Dear Sir/Madam

South Bucks District Council response to The Examining Authority's (ExA) Second Written Questions on the Development Consent Order Application M4 Junctions 3-12 (Smart Motorway)

Drawing title  
SIDE ROAD PLAN & PROFILE  
REGULATION 4(2) (e)  
SHEET 13 OF 13  
OLD SLADE LANE

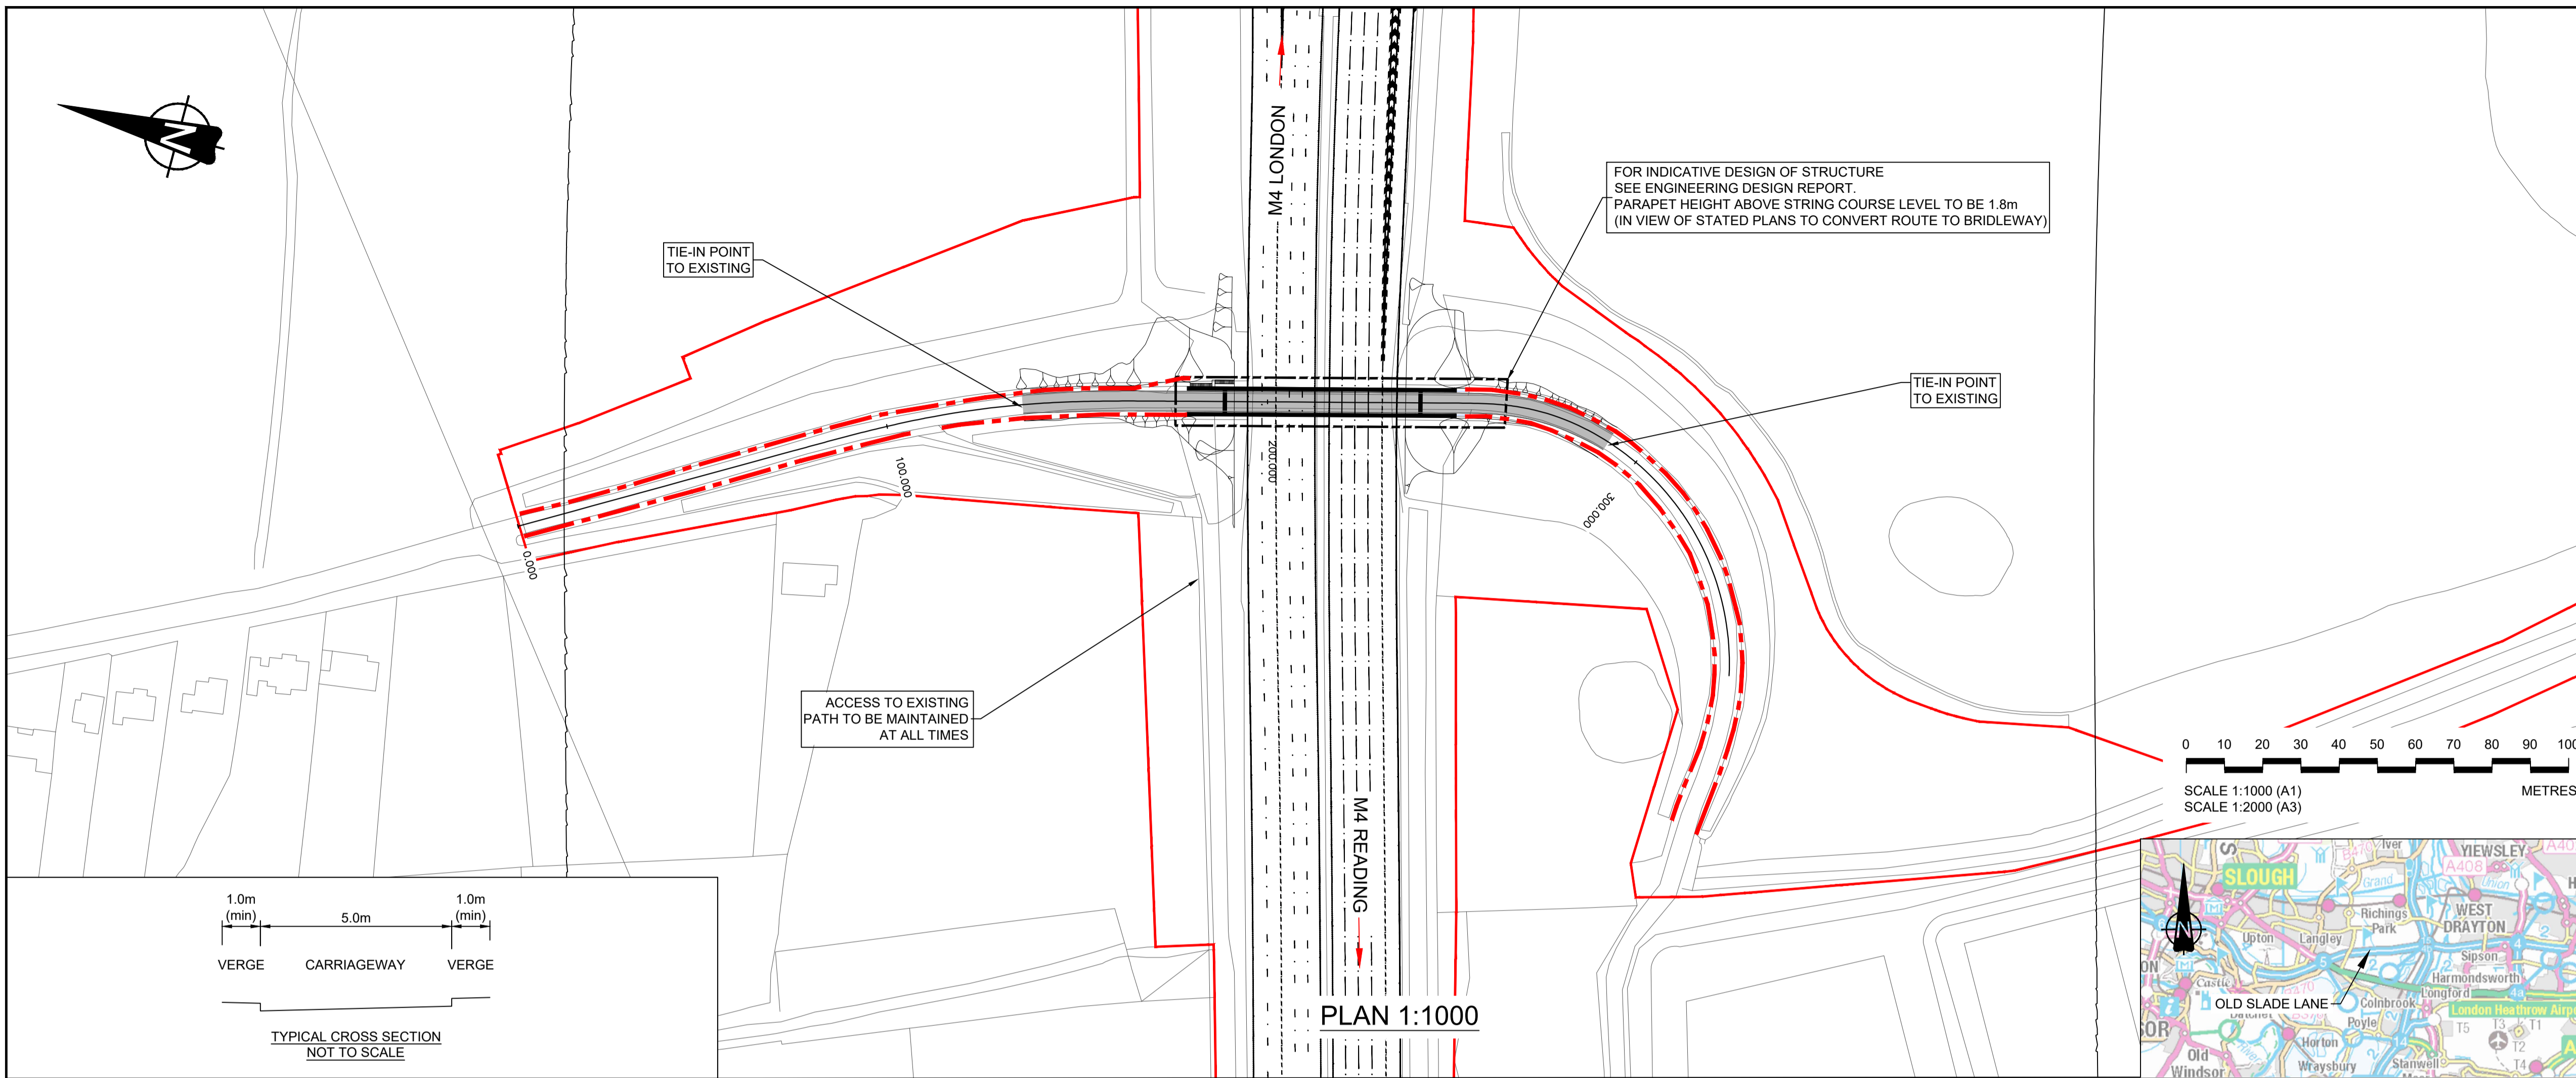
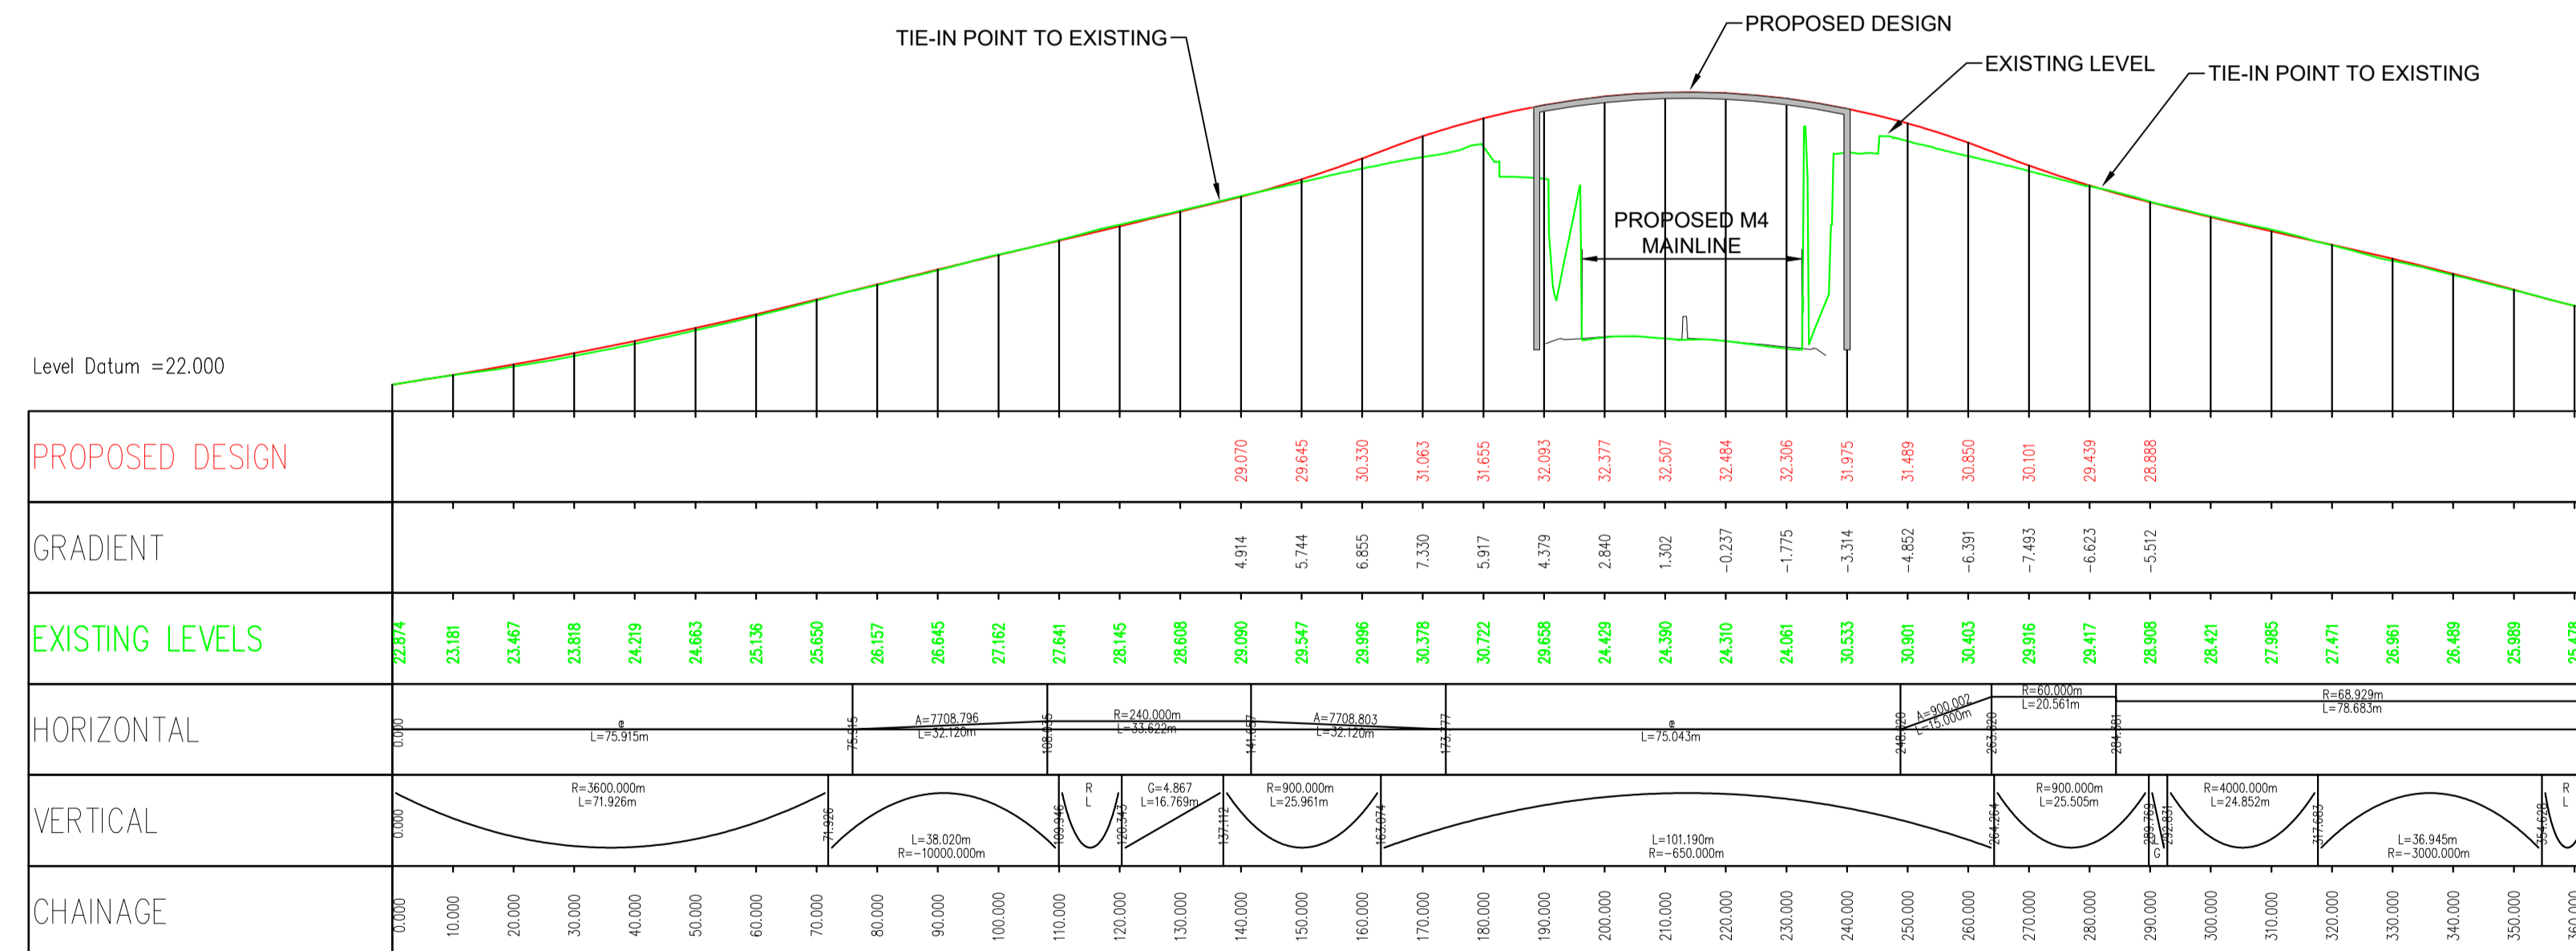
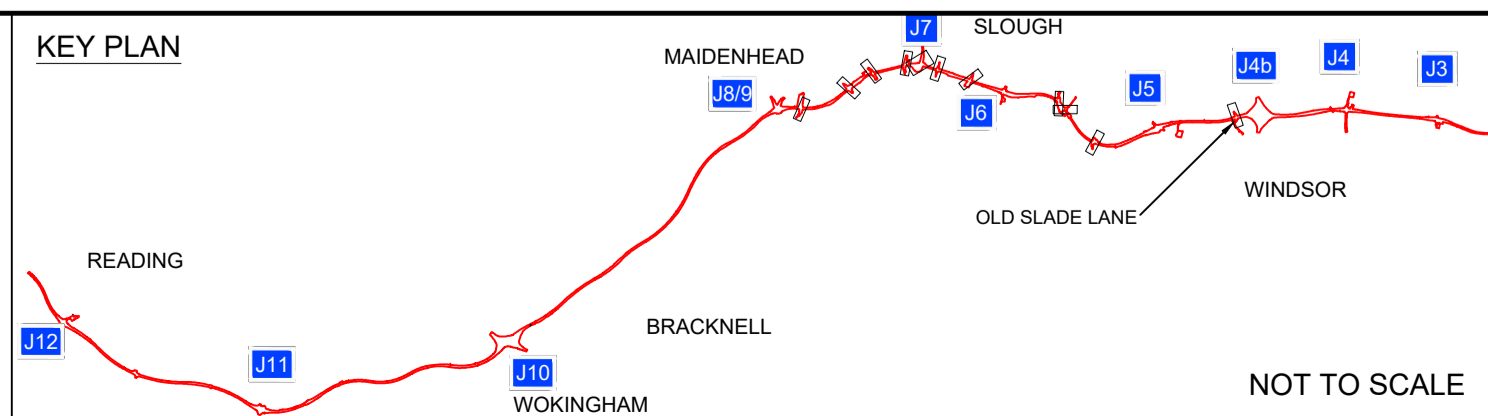
In Iver the two areas of concern are along Little Sutton Lane and Old Slade Lane. The construction of Old Slade Lane Bridge will require the use of Old Slade Lane for construction traffic. The associated HGV traffic will have a negative impact on all the dwellings along this road from the junction with North Park Road.
